Reference No:	2026/62/91551/E
Site Address:	Shepley Carr House, The Carr, Carr Lane, Shepley, Huddersfield, HD8 8BR
Description:	Erection of detached garage and garden room
Recommending Officer:	Nicole Helliwell

Officer Report

Proposal: Erection of detached garage and garden room

PROPOSED ELEVATIONS 1:100 @ A1

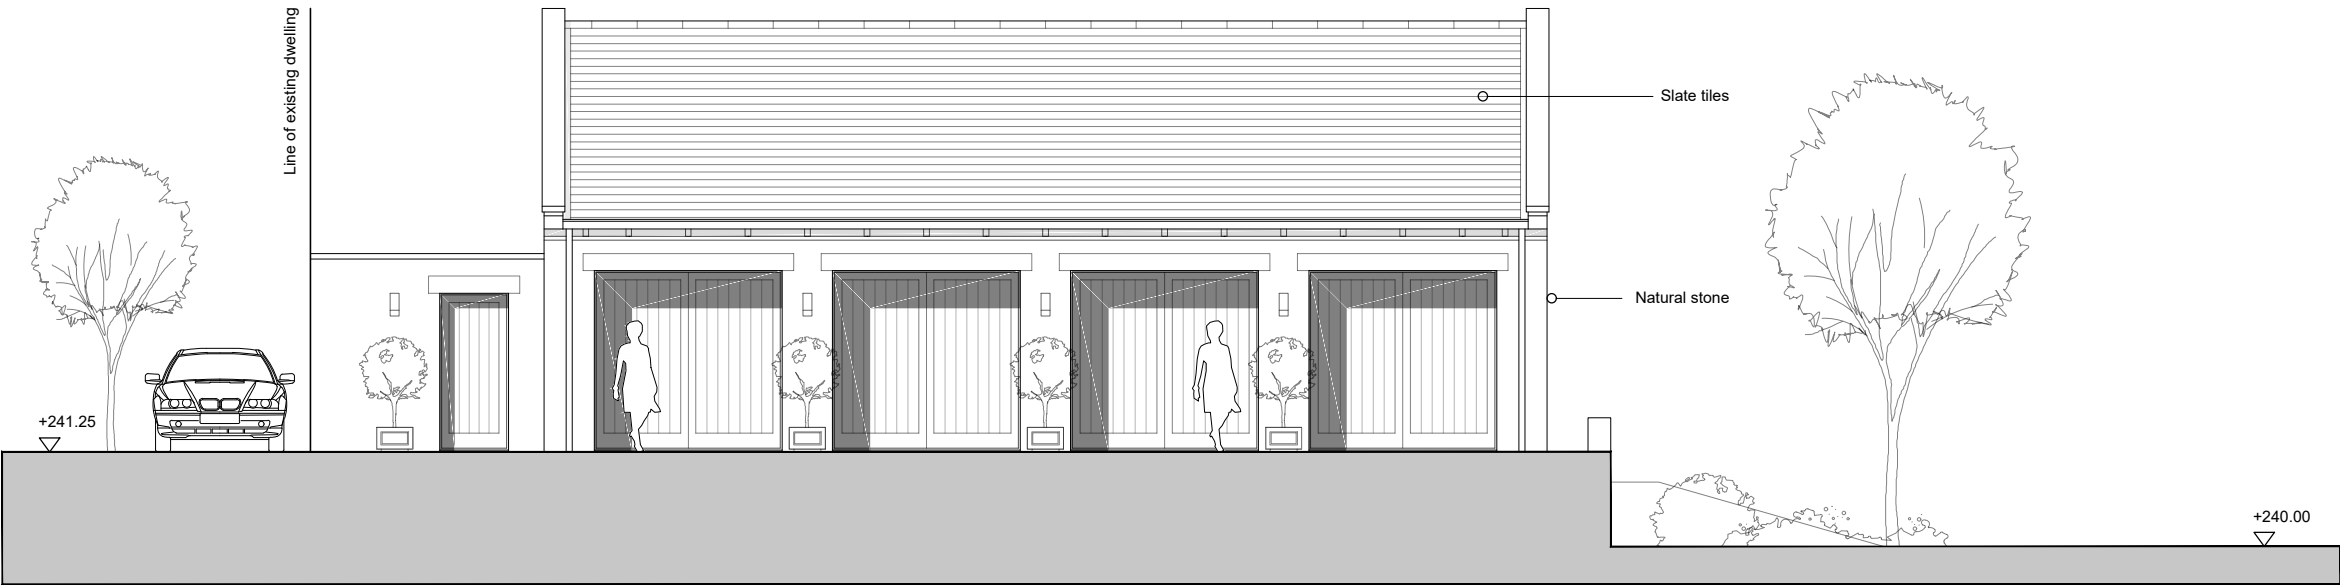
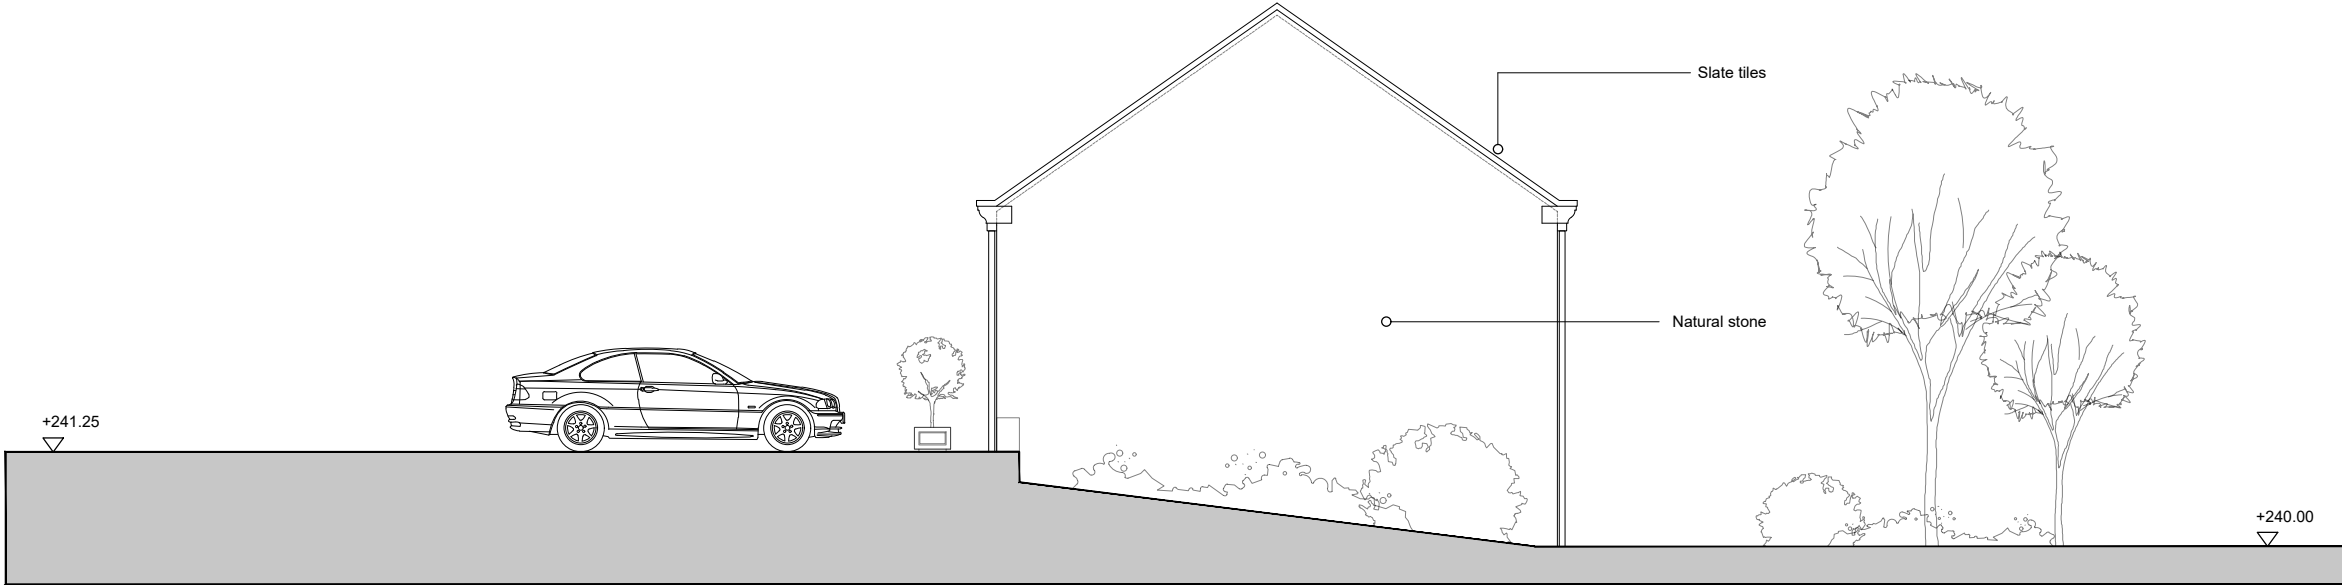
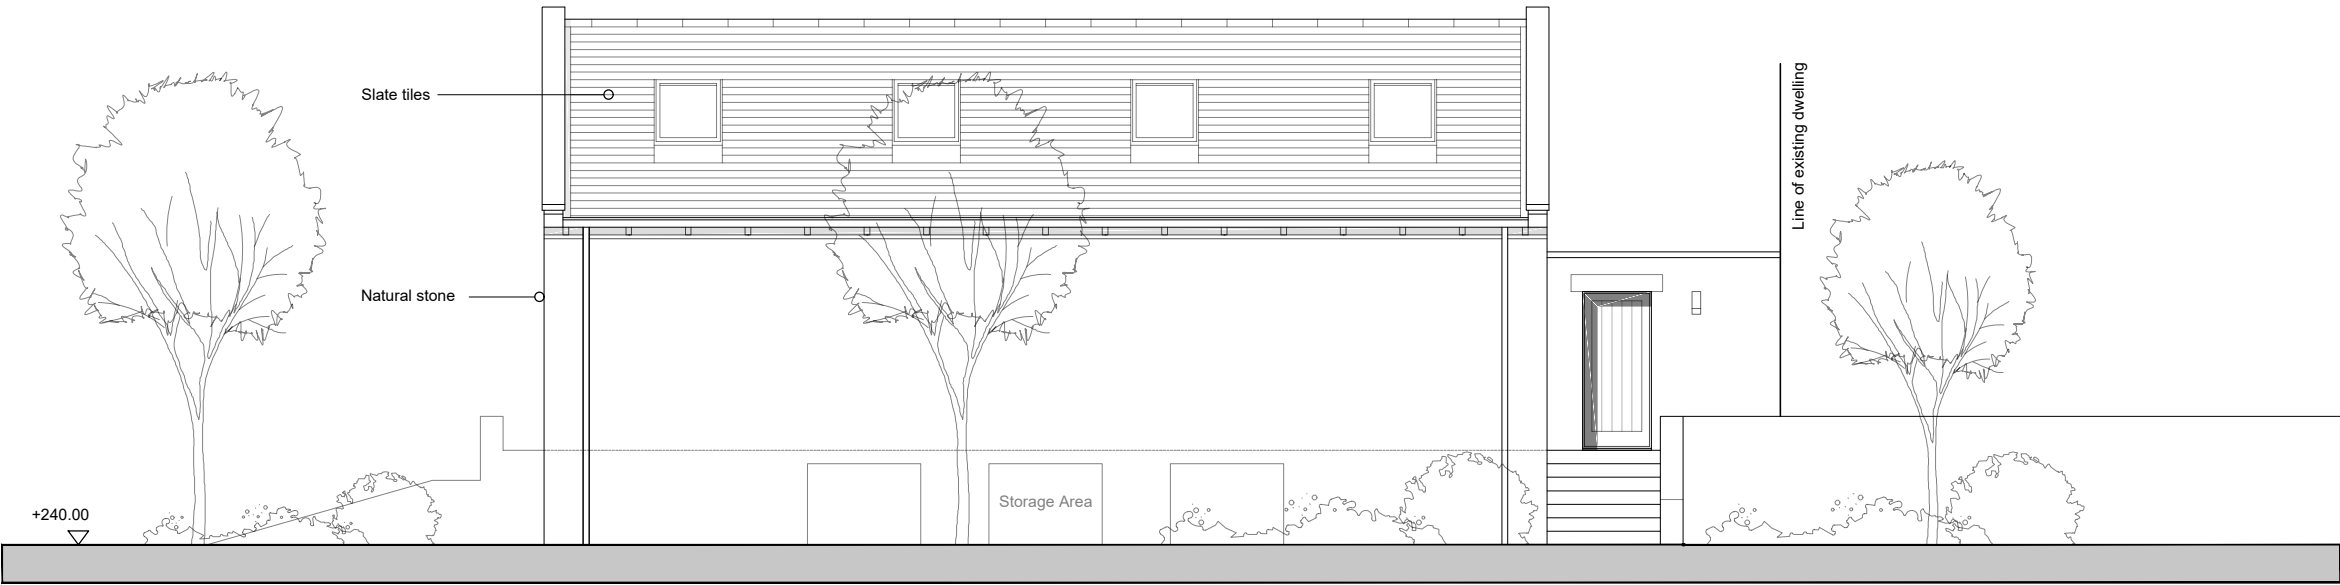
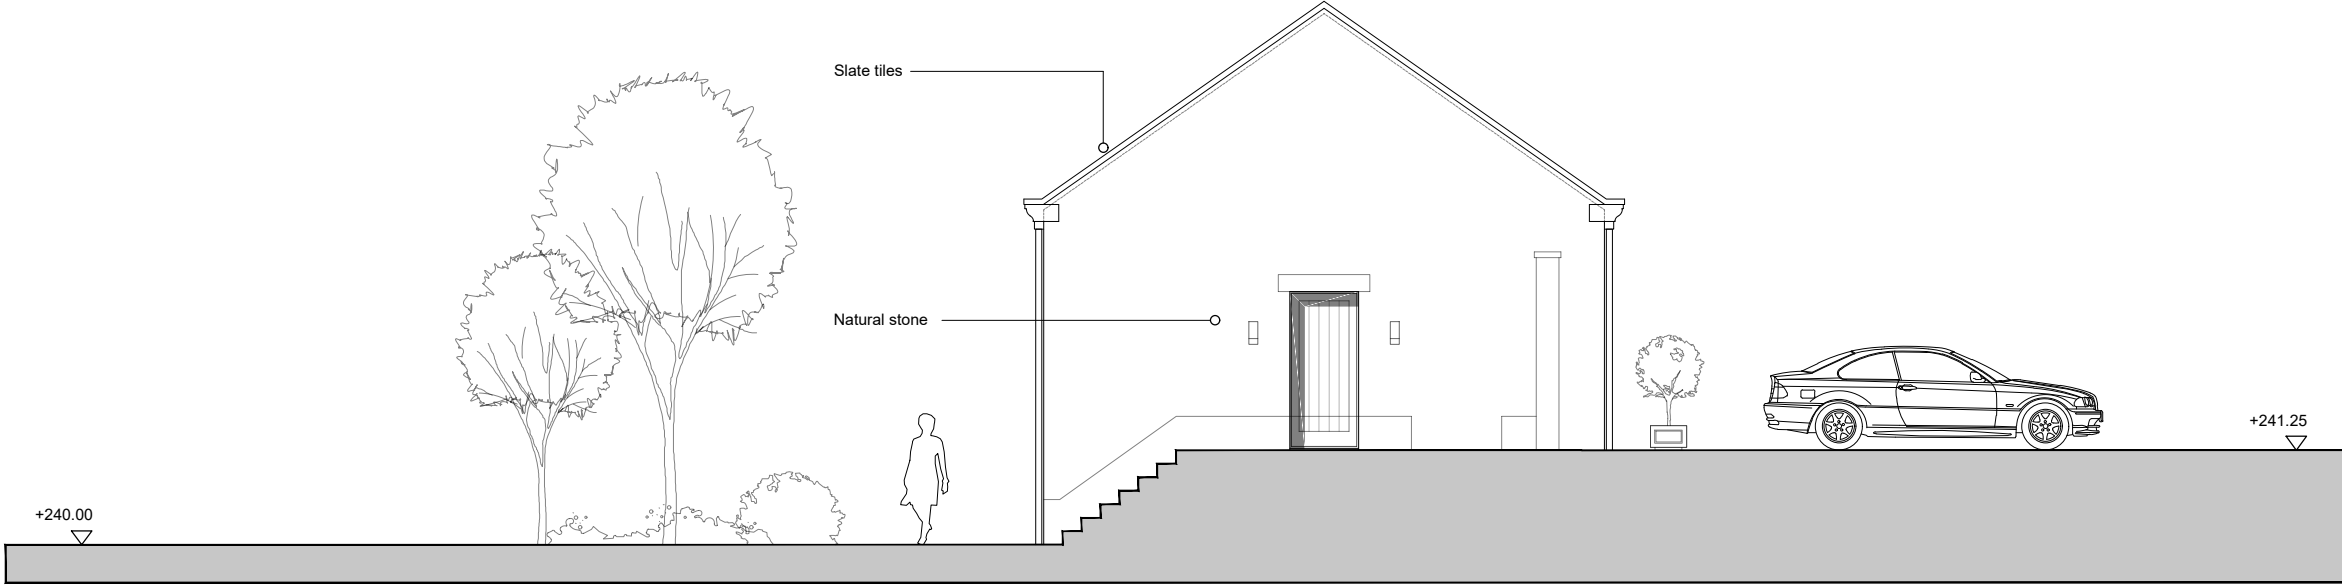
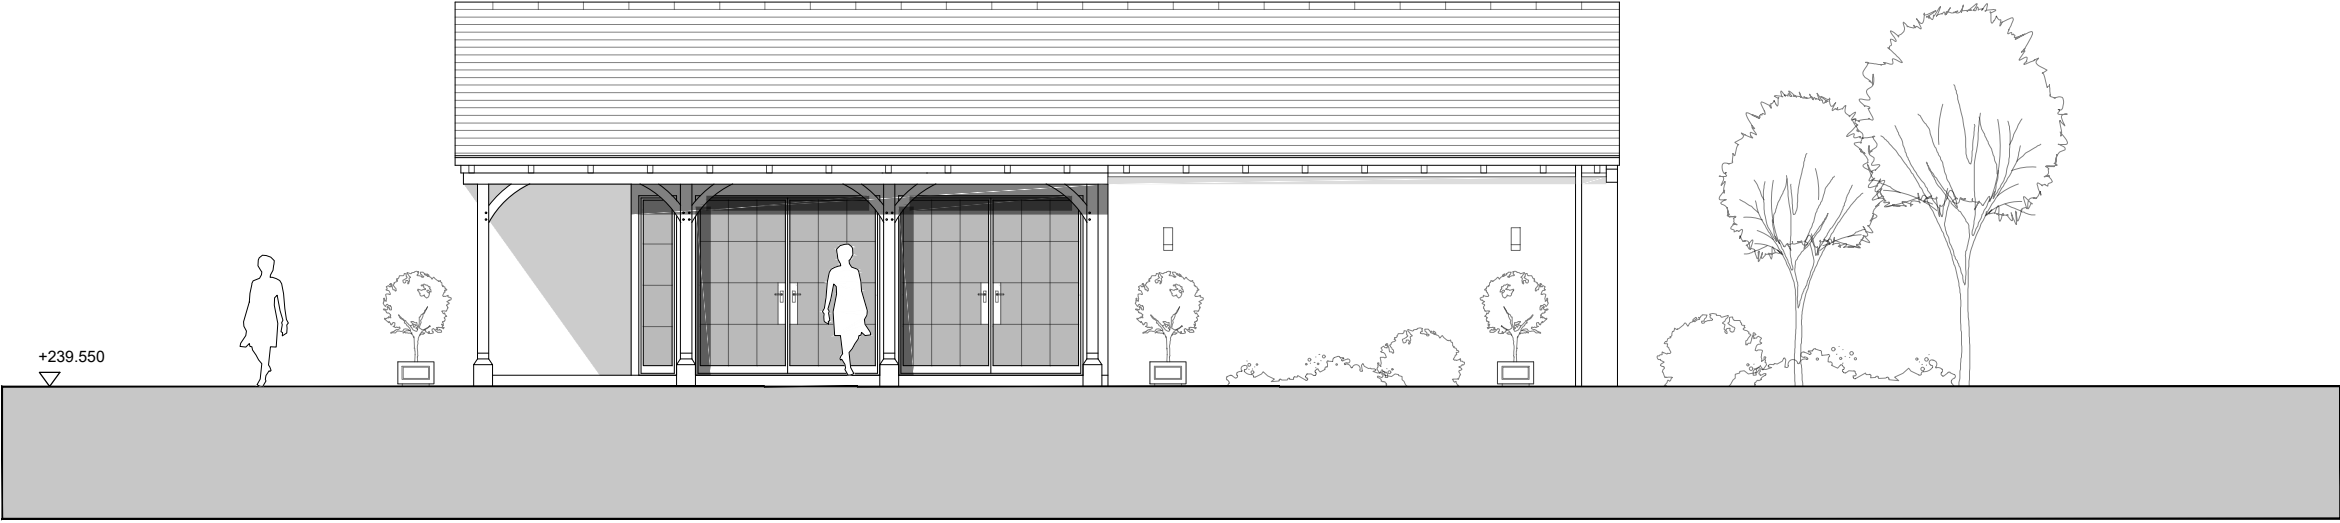
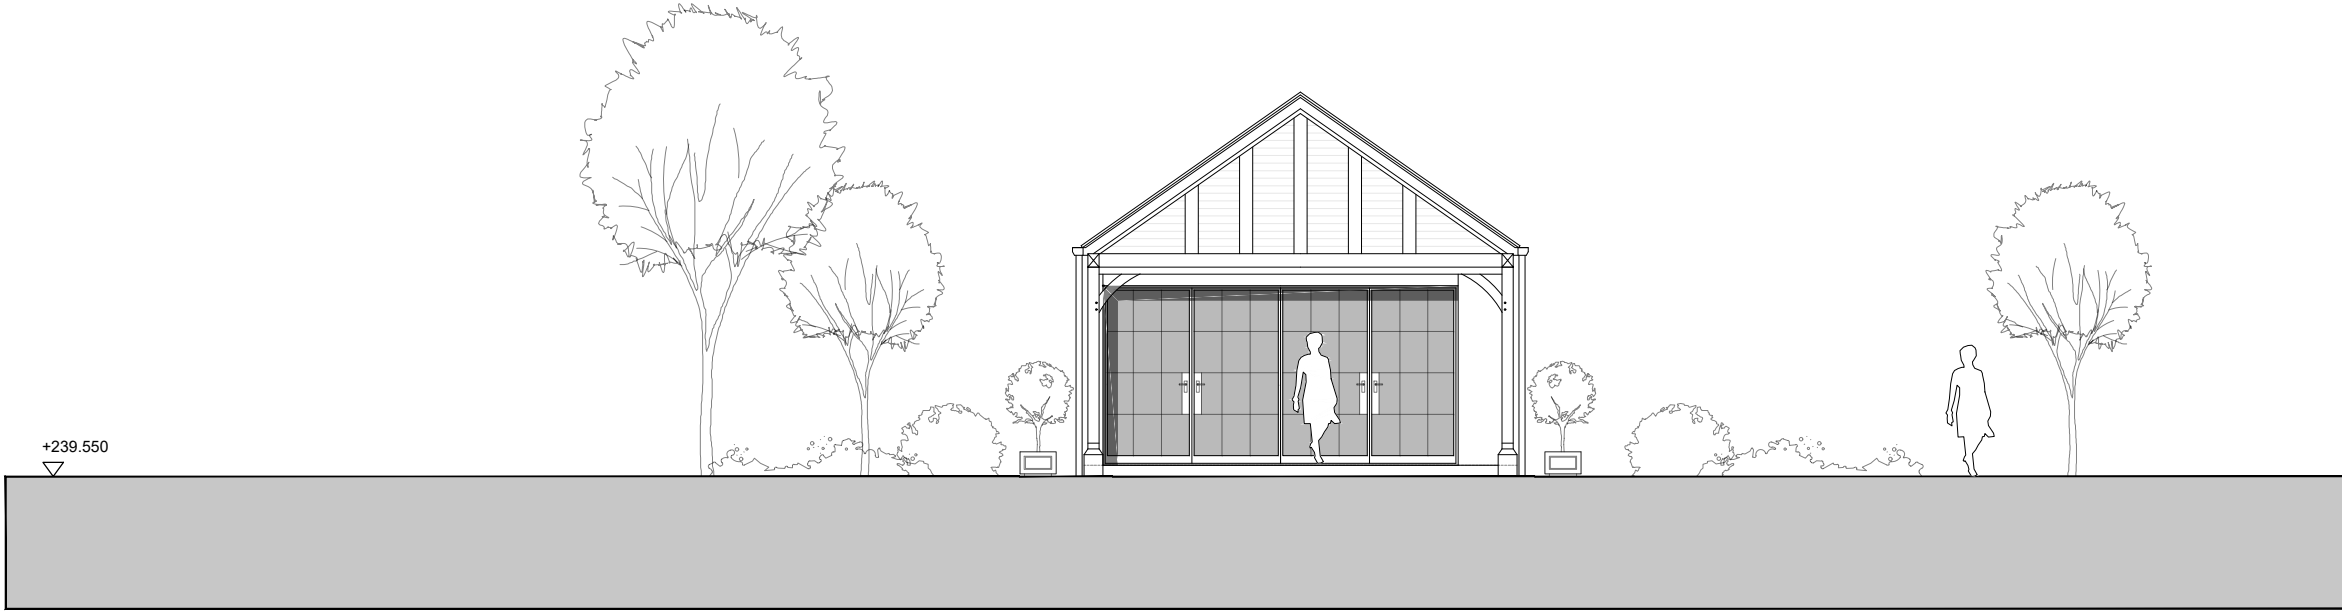
- The submitted architectural drawings are fundamentally deficient, lacking basic transparency and context.
- The elevations completely omit to illustrate the proposed detached Garage and Garden Room/Golf Simulator in direct visual relation to the host dwelling (Shepley Carr House). The structures are drawn in total isolation. Because the house is an irreplaceable heritage asset, the applicant has a strict duty to provide contextual elevations under Policy LP35 to demonstrate how the proposal preserves its setting.

- The drawings completely fail to state the proposed ridge heights, eaves heights, or exact structural dimensions for either the Garage or the Garden Room. Scale analysis of site plan drawing shows that the proposed Garden Room and Golf Simulator features an elongated footprint measuring approximately 14.5 metres in length by 4.5 metres in width, while the Garage measures approximately 10.5 metres in length by 5.5 metres in width. Without clear vertical dimensional data matching these large horizontal footprints, the council cannot mathematically evaluate the level of

overshadowing to neighbouring plots or the visual dominance on the heritage asset. The application remains technically un-assessable.

Officer Comments: *The drawings and details have been submitted in line with the Kirklees Planning Validation Requirements. Whilst the drawings do not state the measurements of the proposed development, the plans contain a metric scale and officers have been able to accurately assess the proposal.*
